CITY OF ALBUQUERQUE

March 18, 2020

Re: ABQ RV & Boat Storage
2201 Vista Oriente Street NW
Traffic Circulation Layout
Engineer's Stamp 03-16-2020 H10-D030)

SHEET TITLE:
TRAFFIC CONTROL LAYOUT

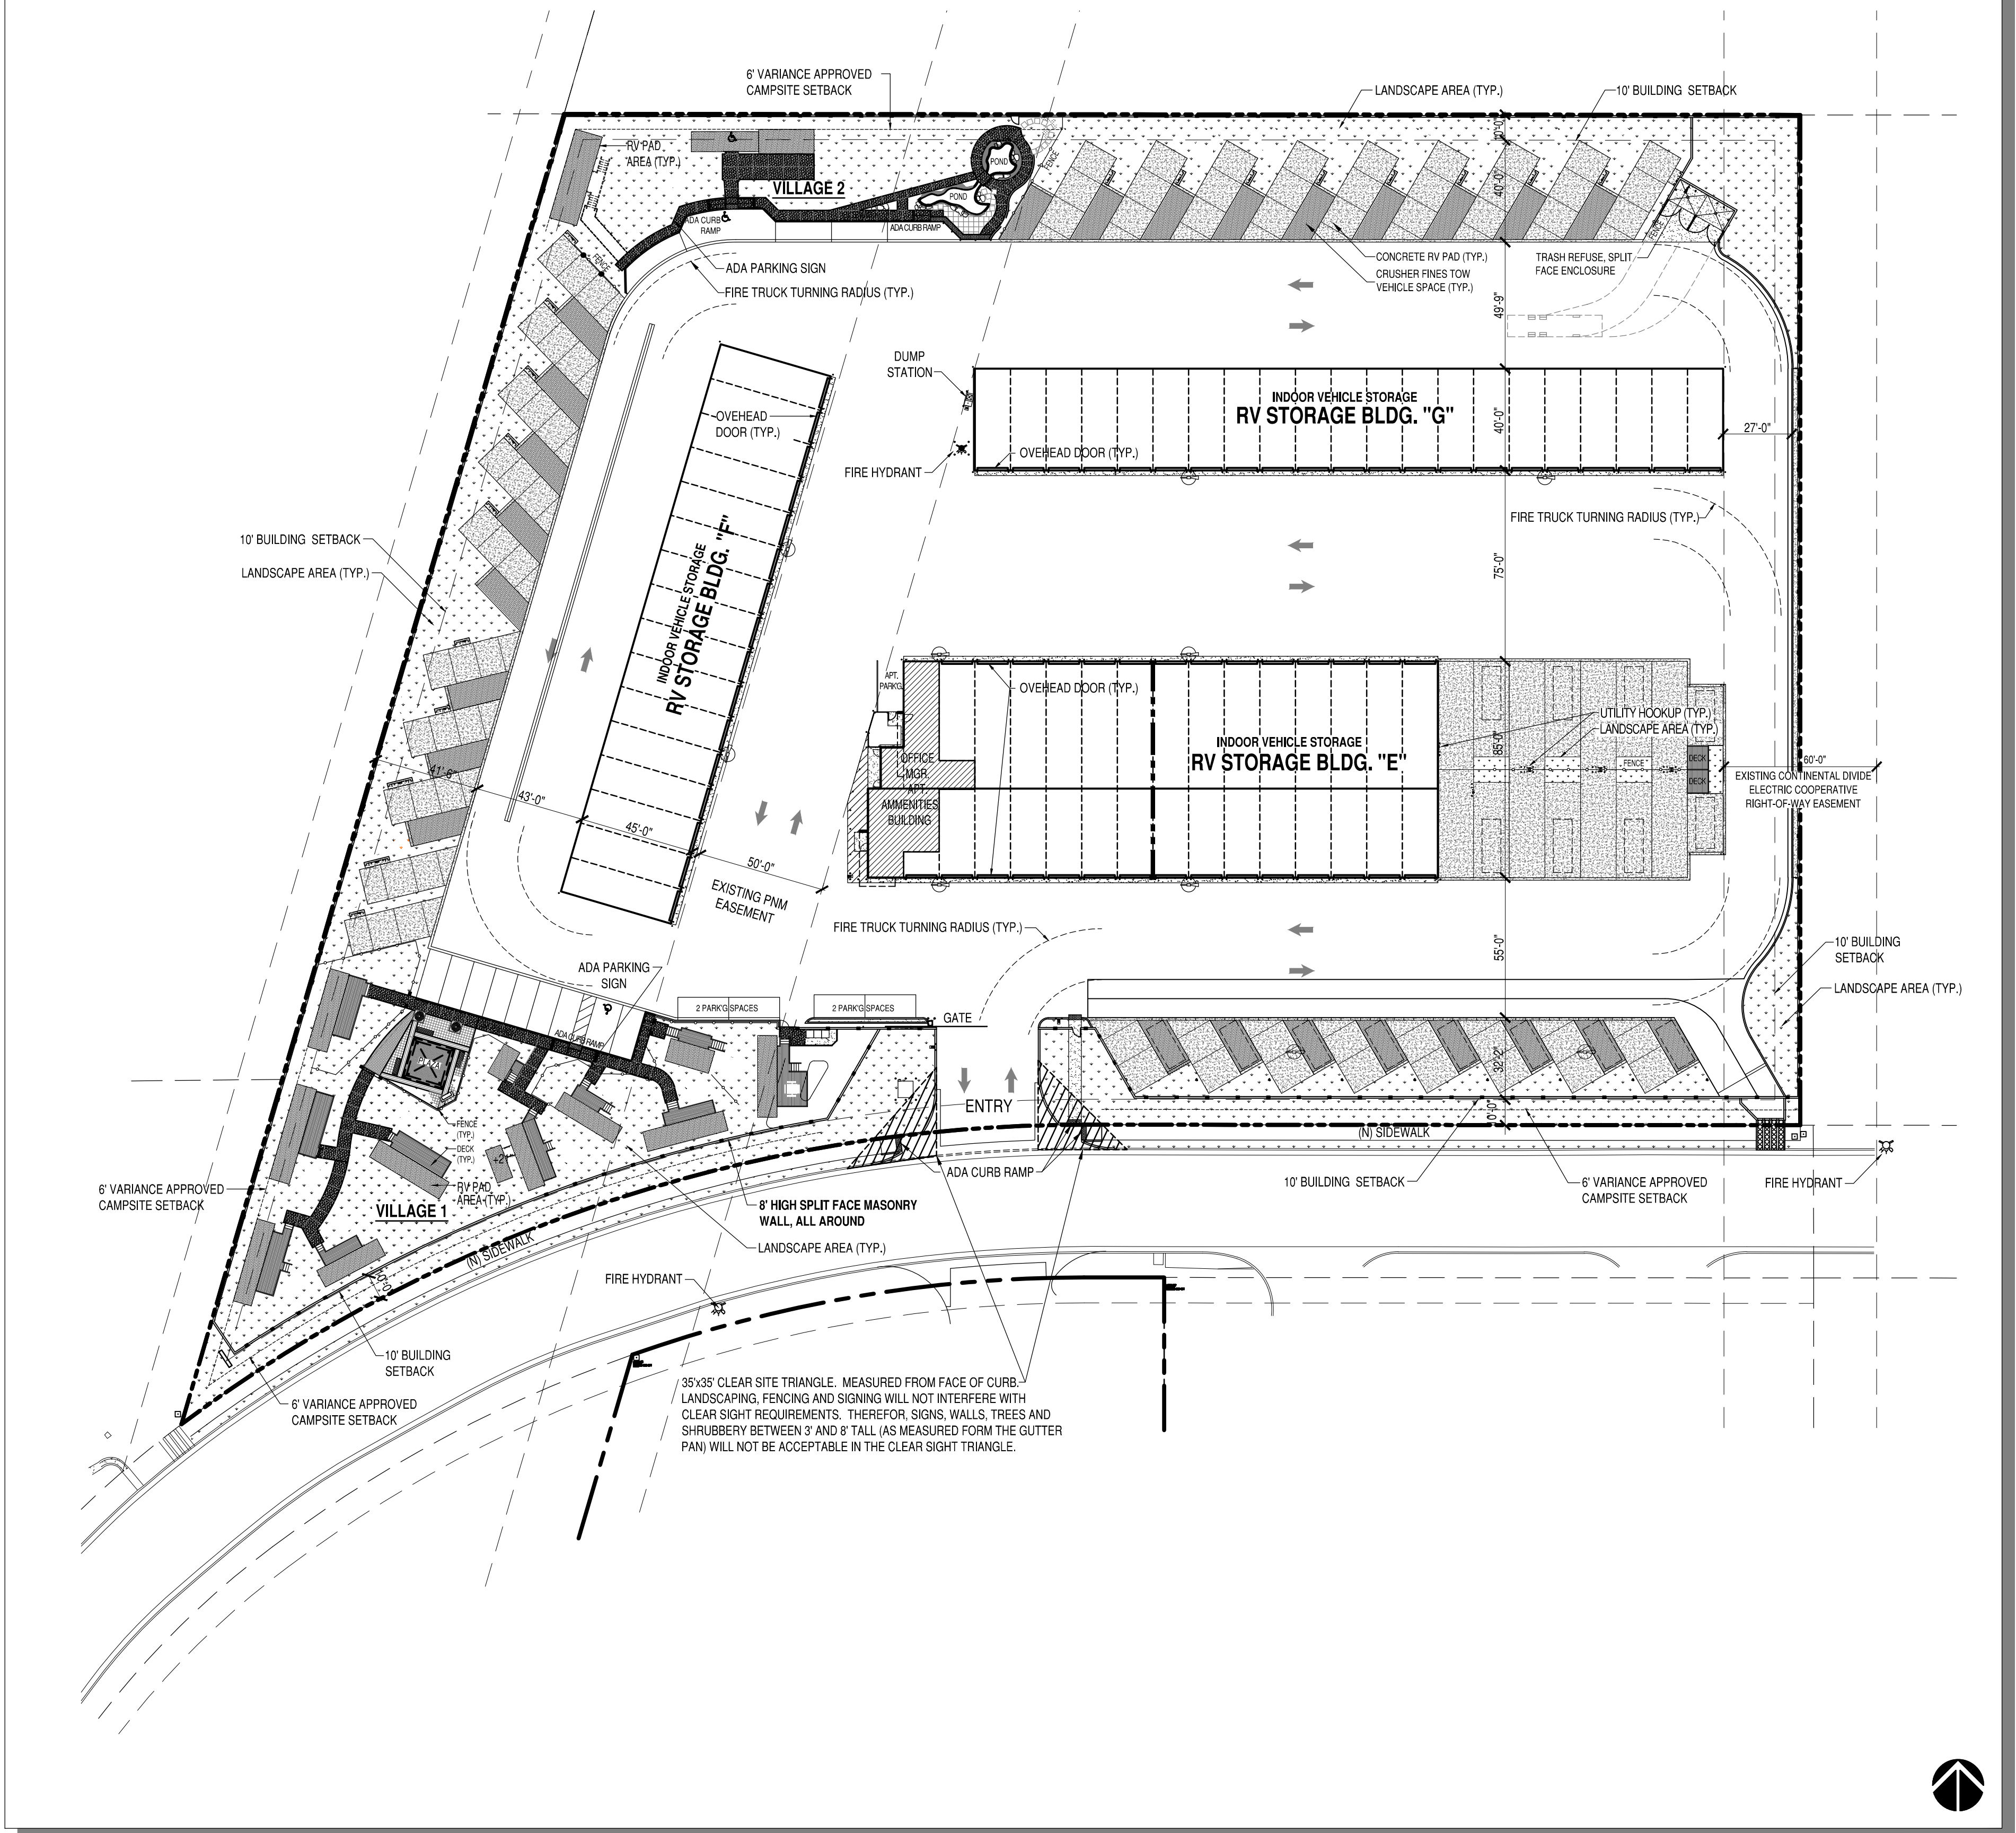
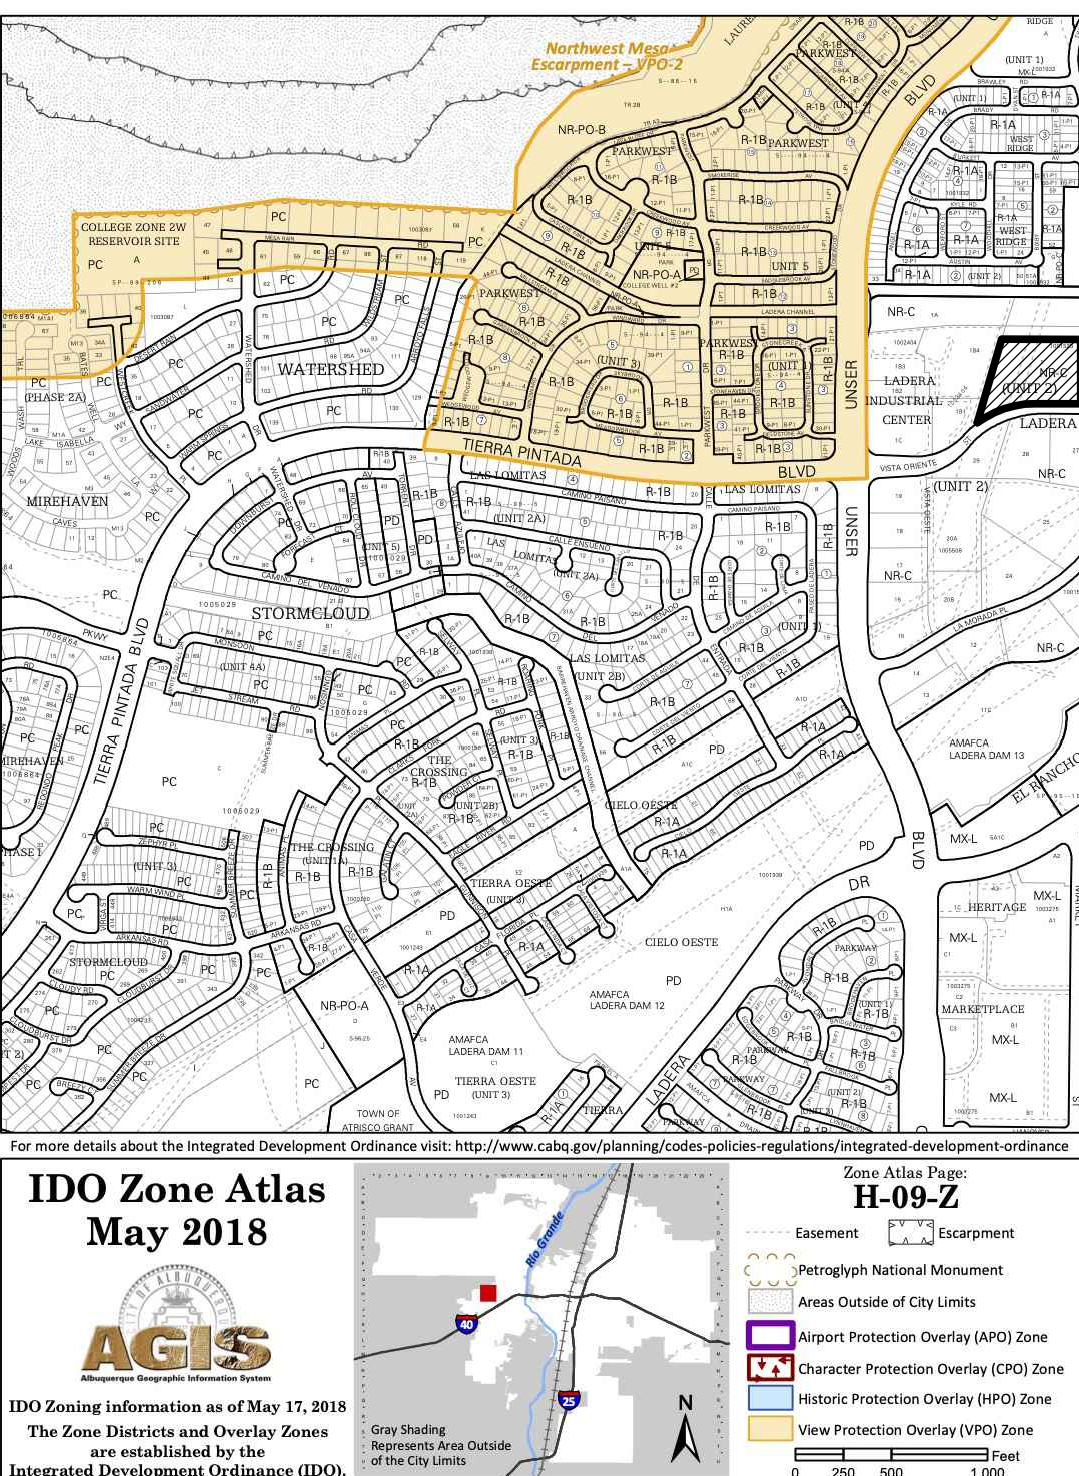
1. Please review and revise plan to provide all information listed on the attached Traffic Circulation Layout checklist.
2. Label Site Plan Traffic Circulation Layout instead of Traffic Control Plan.
